MMC Ph III Medical Office Bldg: PL331-2018

My preliminary comments regarding site access, sidewalk, street, streetscape and public realm are as follows:

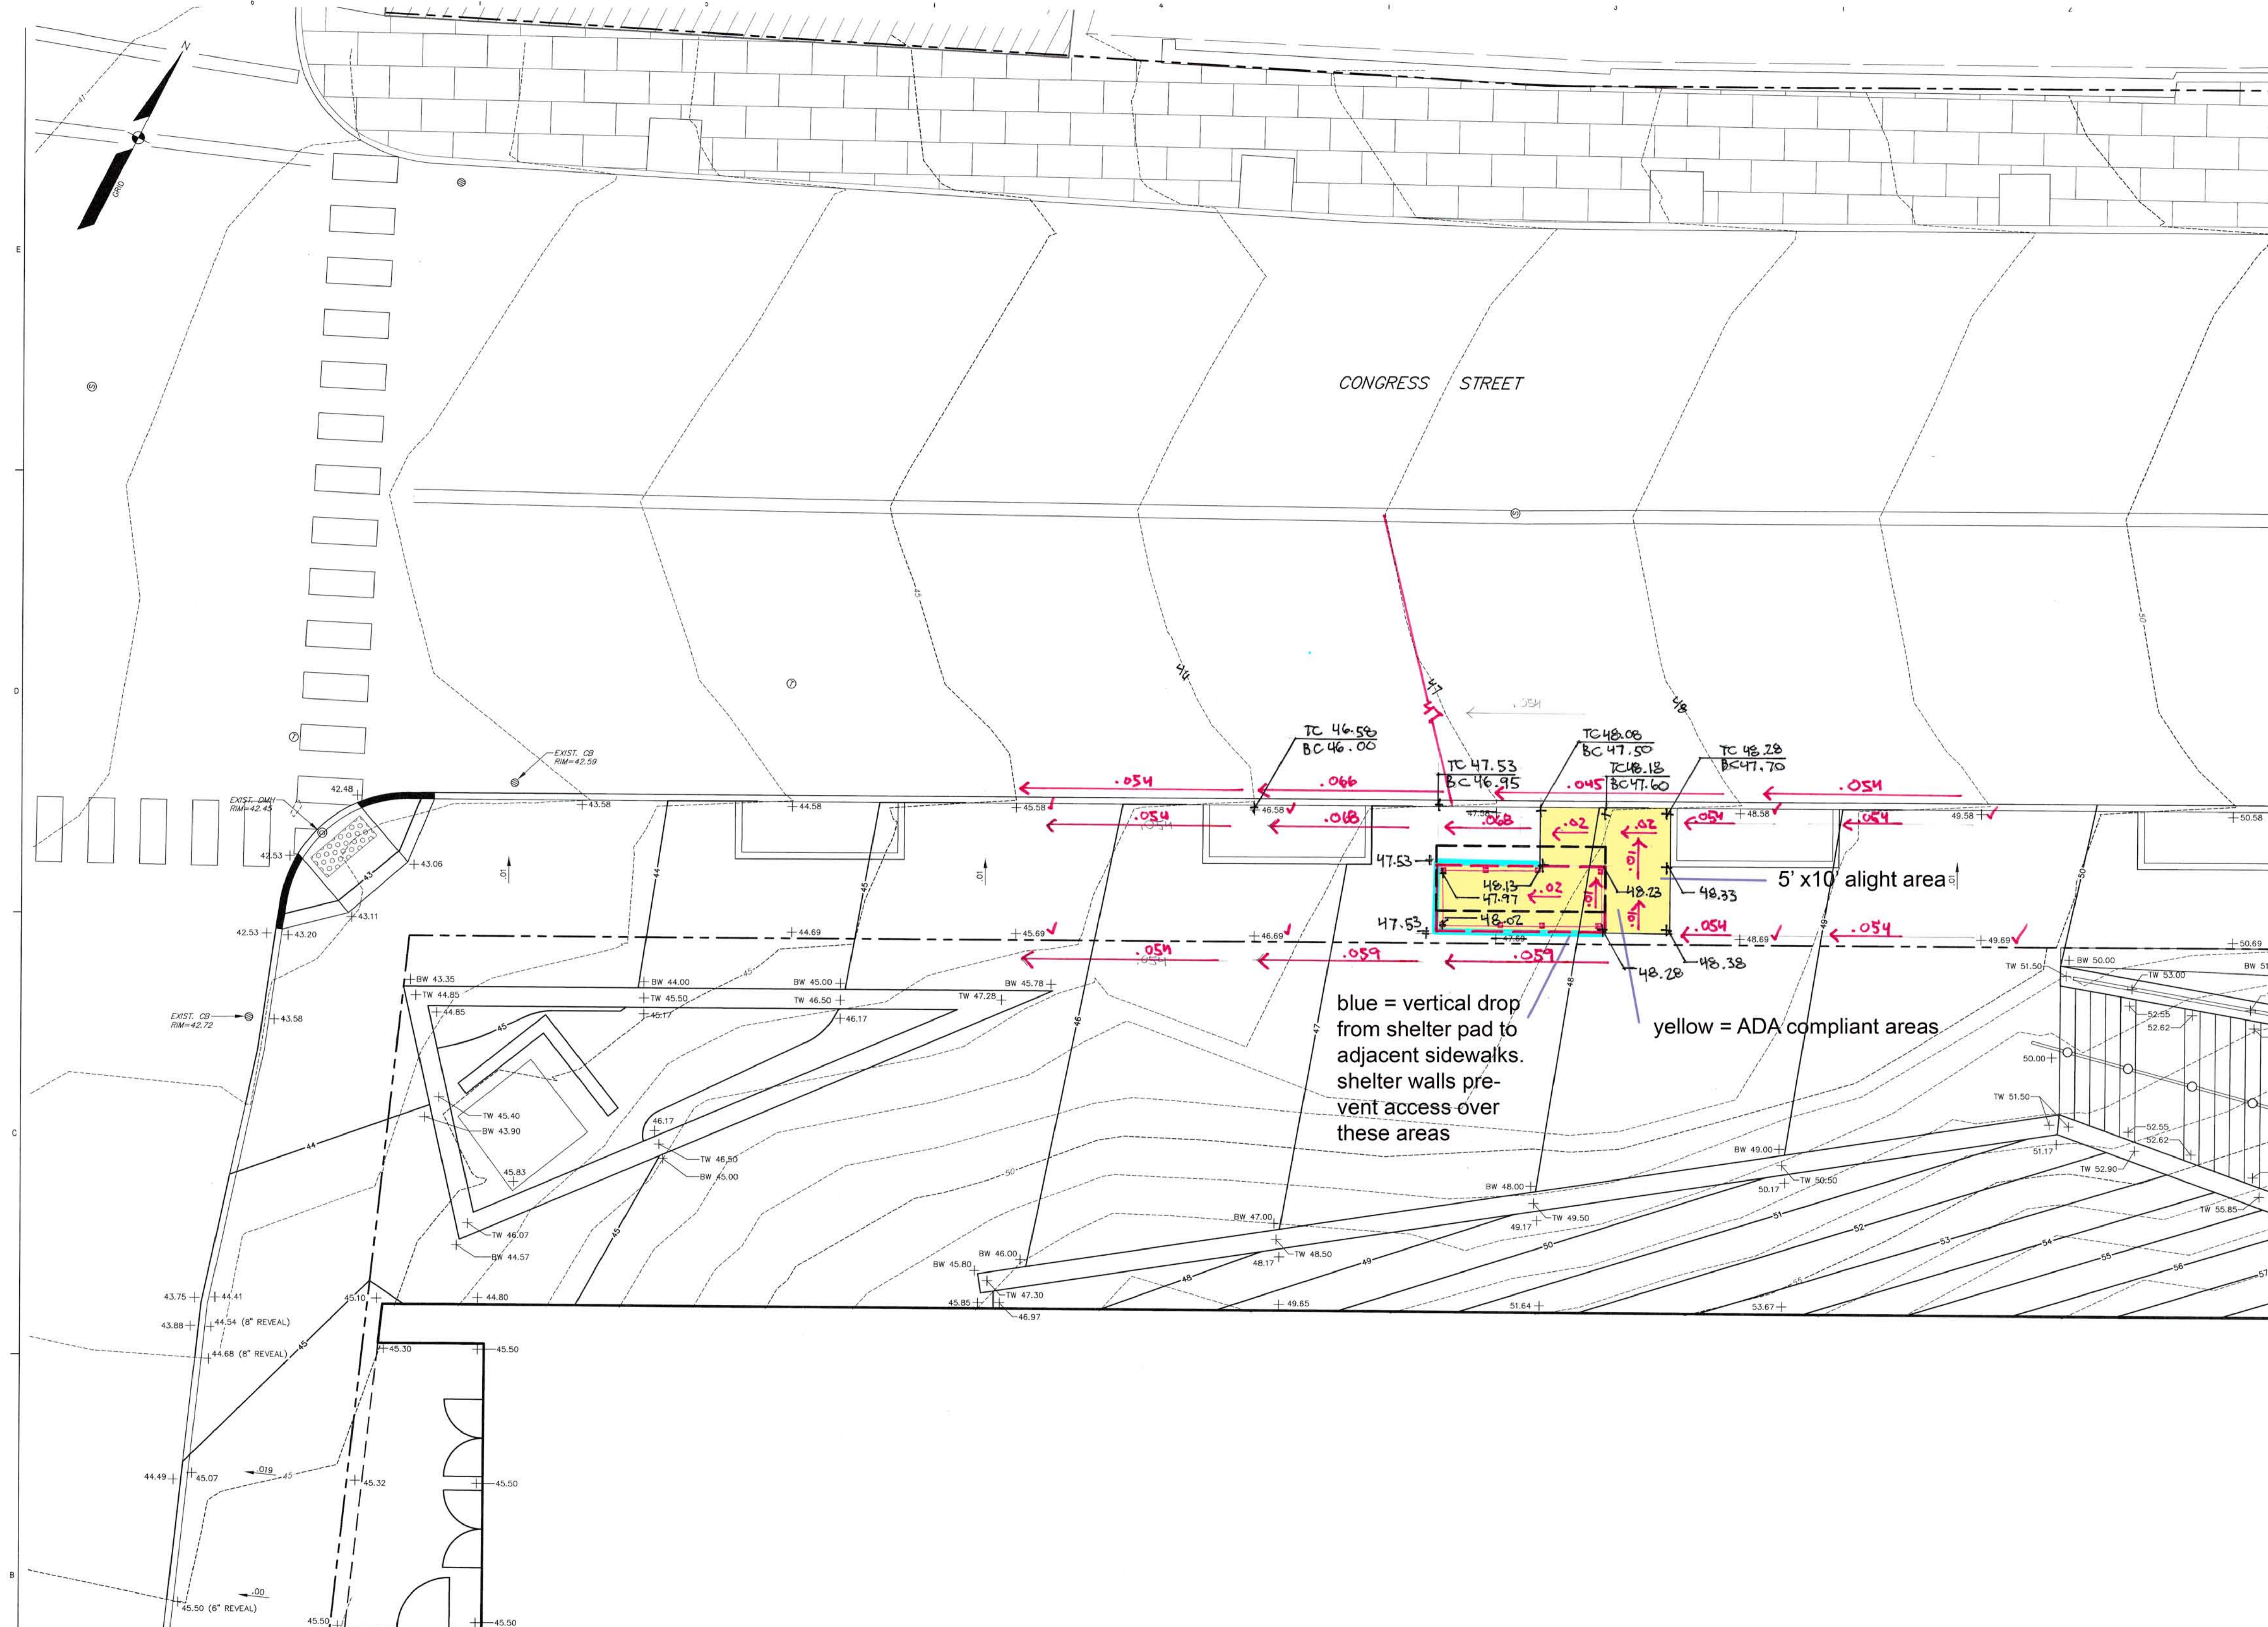
- The site plan key identifies #14 as "Bus Stop" but the elevations show a bus shelter - there is not sufficient bus landing area (5'x8' minimum") provided if a bus shelter is intended (or unless the landing area includes a portion interior to the shelter as the landing area - which is not preferred)

**C40-01**

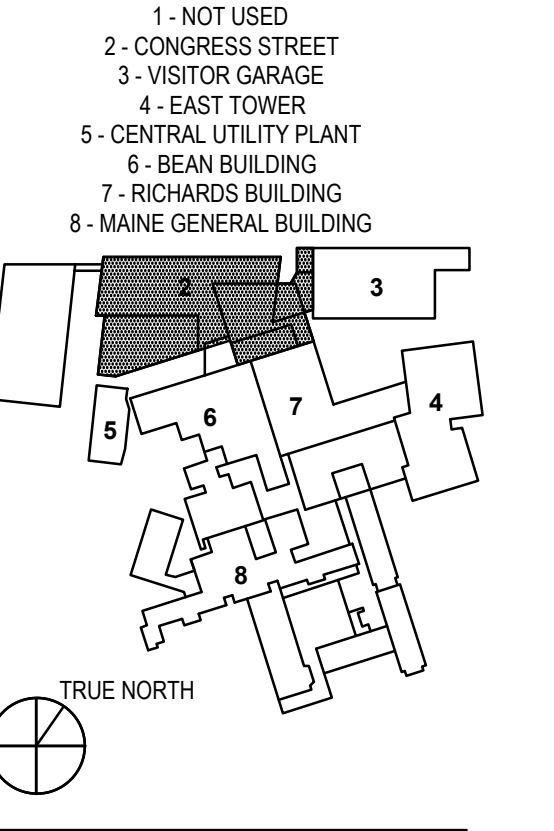
- I don't believe, based on the grading plan submitted, (C40-01/02) that the curb ramps serving the mid-block crosswalk meet ADA in terms of cross-slope (2% max. cross-slope) nor that the area shown for the bus stop has a bus landing area that meets ADA. Please document the ADA analysis.
- The grading plan for Gilman St appears incomplete/not shown in its entirety. Please show the entire site.
-
